Application Ref:	3/2025/0218			 Ribble Valley Borough Council <hr/> www.ribblevalley.gov.uk
Date Inspected:	13/05/2025	Site Notice:	13/05/2025	
Officer:	MC			
DELEGATED ITEM FILE REPORT:				APPROVAL

Development Description:	Proposed 1.25m high garden wall and new gate piers set back 5.5m from highway (retrospective).
Site Address/Location:	Cherry Yate, Stoneygate Lane, Ribchester, PR3 3YN

Existing and Proposed Site Layout Plans

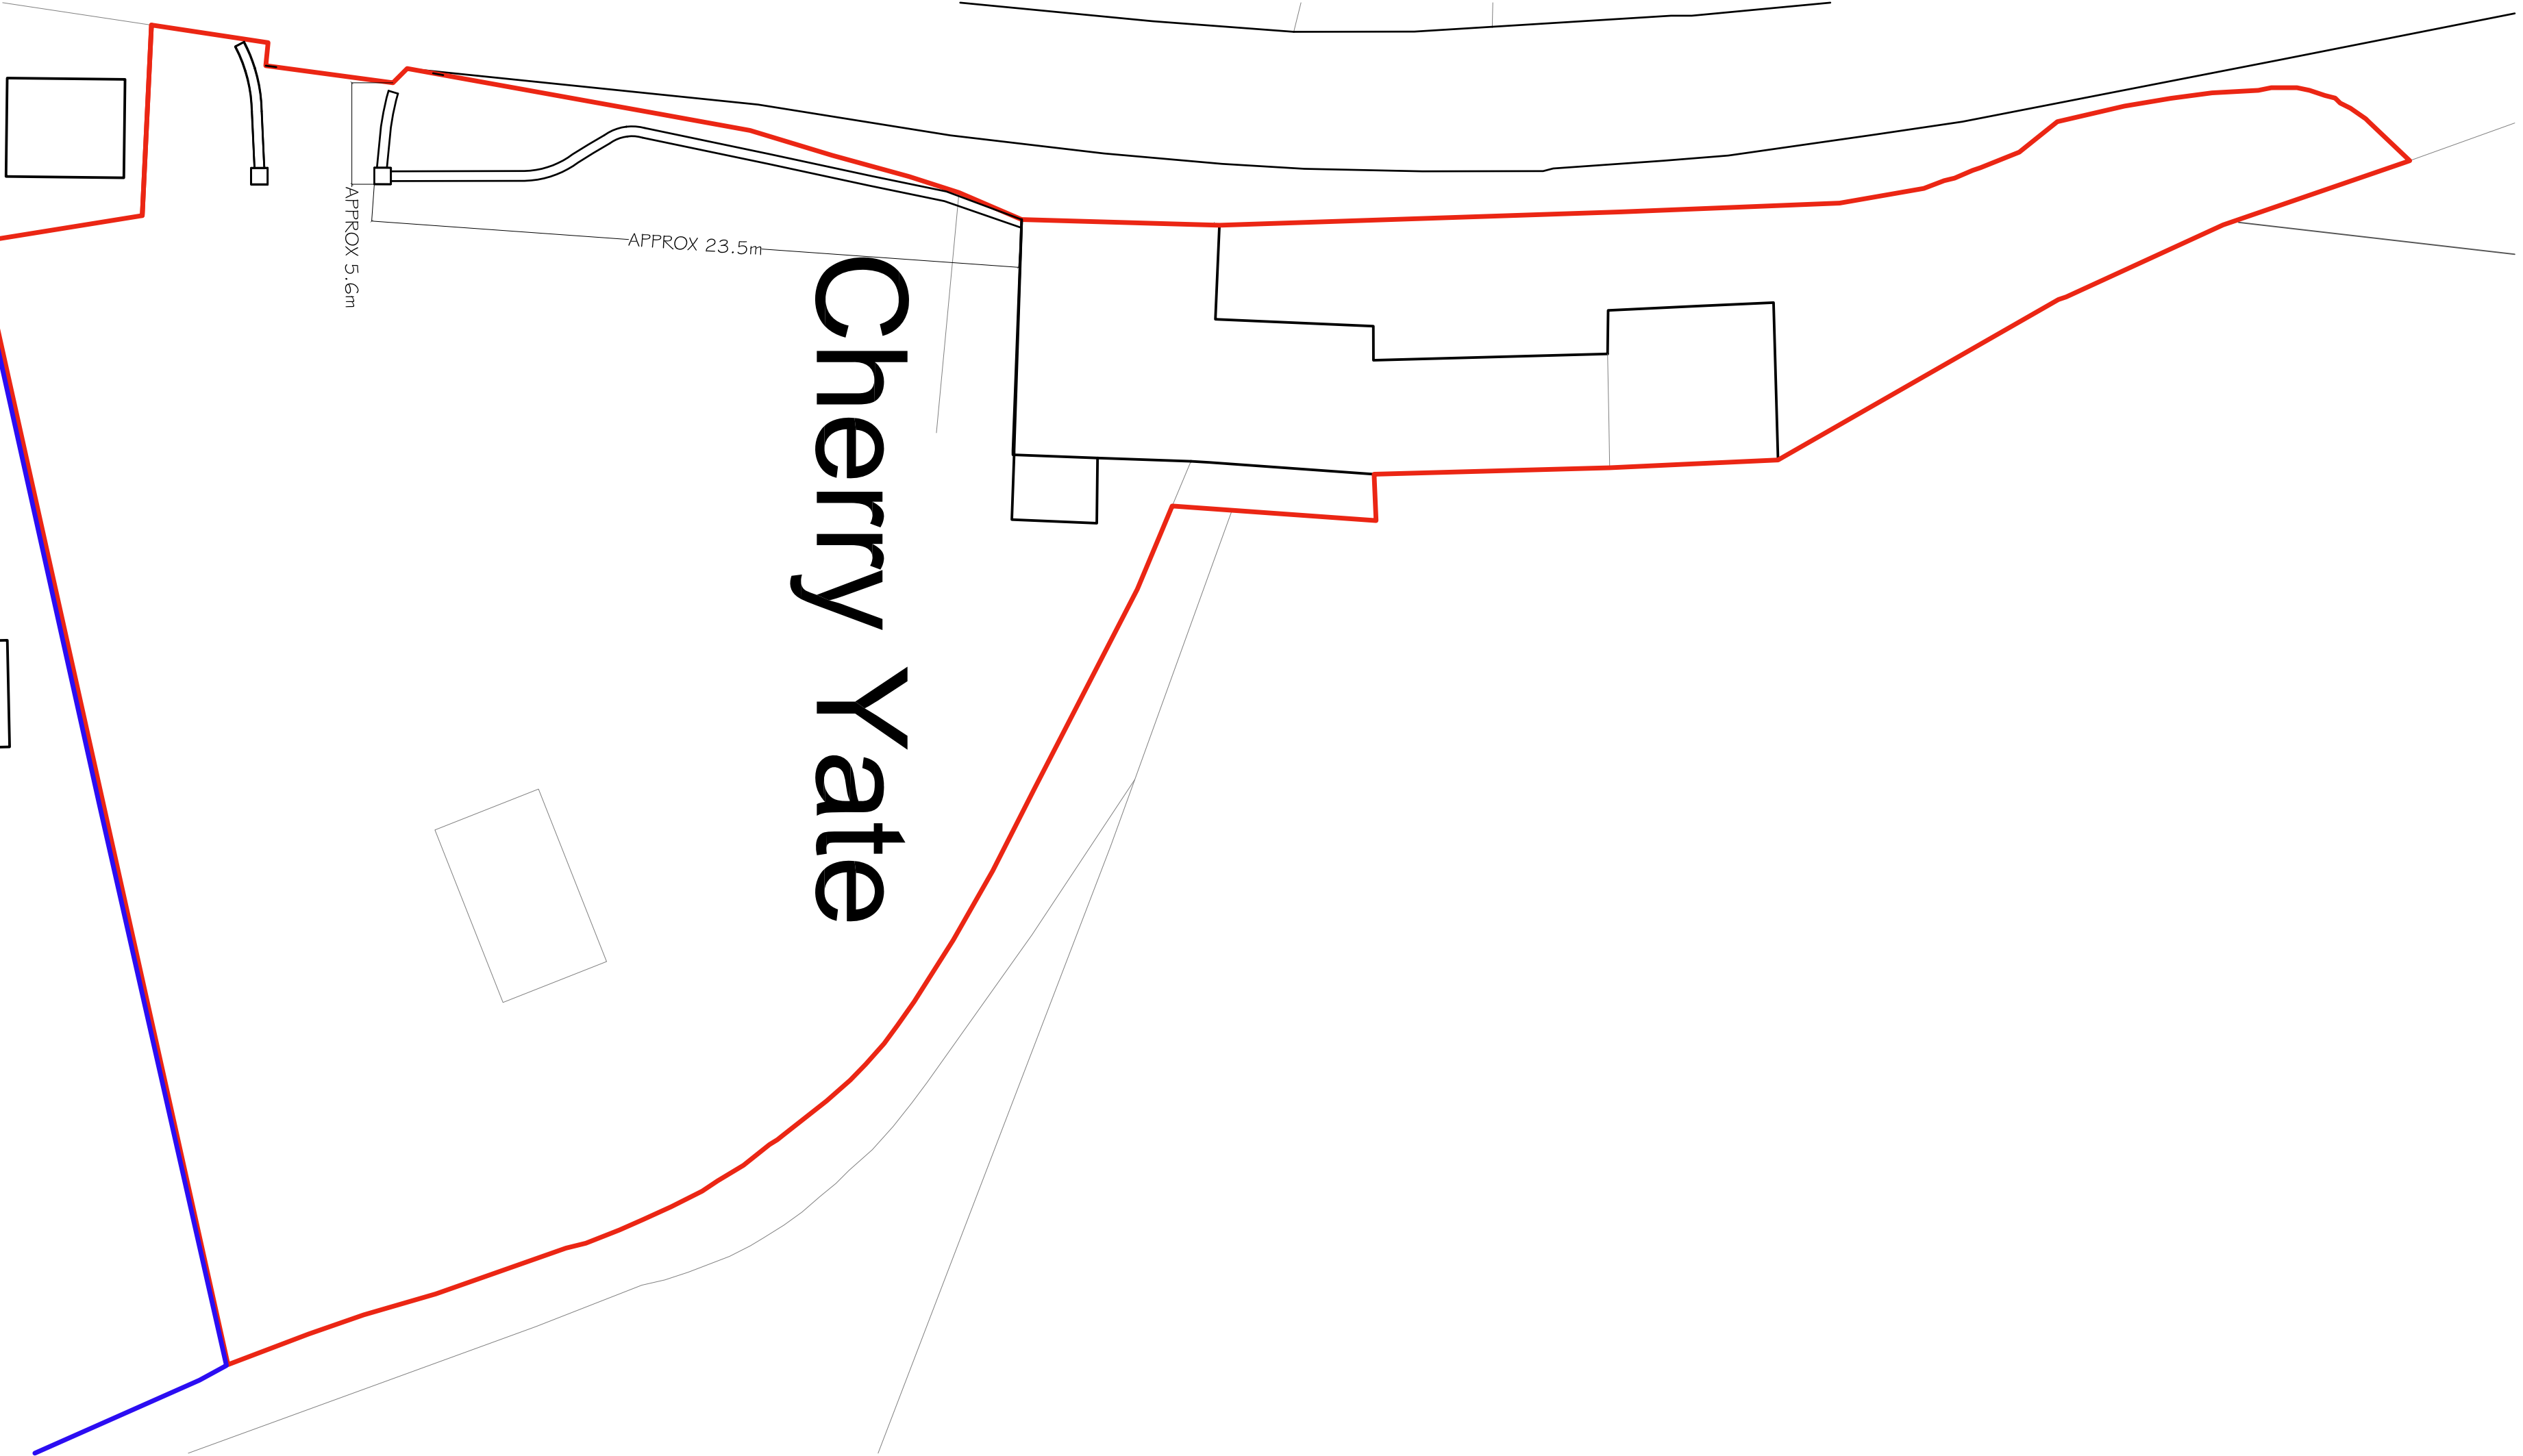
CONSULTATIONS:	Highways/Water Authority/Other Bodies
LCC Highways:	Following amendments received to set back part of the wall from the highway to achieve visibility splays, the LHA recommend approval subject to conditions which require the applicant to amend the gateposts to a minimum of 5m behind the nearside edge of the carriageway, ensure the access is appropriately surfaced before its use and the provision of wheel washing facilities.
CONSULTATIONS:	Additional Representations.
No additional representations received.

Following discussions with the highway authority, the drawings have been amended so that the splayed wall would be cut back approximately 750mm to behind the sightline as indicated on drawing ref: A4553-PL02 Rev C and the entrance to the access surfaced in tarmac.

The Highway Authority originally objected to the proposal due to the lack of visibility splays being achieved. The applicant notes that to the south, visibility is limited due to the presence of the neighbouring hedge, however following ongoing discussions between the LHA and the agent for the application, it has been agreed that the northern splayed wall would be cut back by approximately 750mm to achieve a suitable visibility splay. This can be secured by way of condition. In addition, they recommend a condition to ensure the access is appropriately surfaced and wheel washing facilities provided throughout construction. Whilst the majority of the works have been undertaken, it would not be unreasonable to include this condition, given that further works are required to remove the wall and provide additional surfacing to the access.

The loss of hedgerow is regrettable and it is considered that the installation of the new stone wall could have resulted in some harm to the roots of the existing tree and the proposed amended plans show that the tree crown extends beyond the new wall. Notwithstanding this, the tree is not protected by way of Tree Preservation Order so could be removed without consent and any damage to the roots of the tree would likely have already occurred as the application is retrospective.
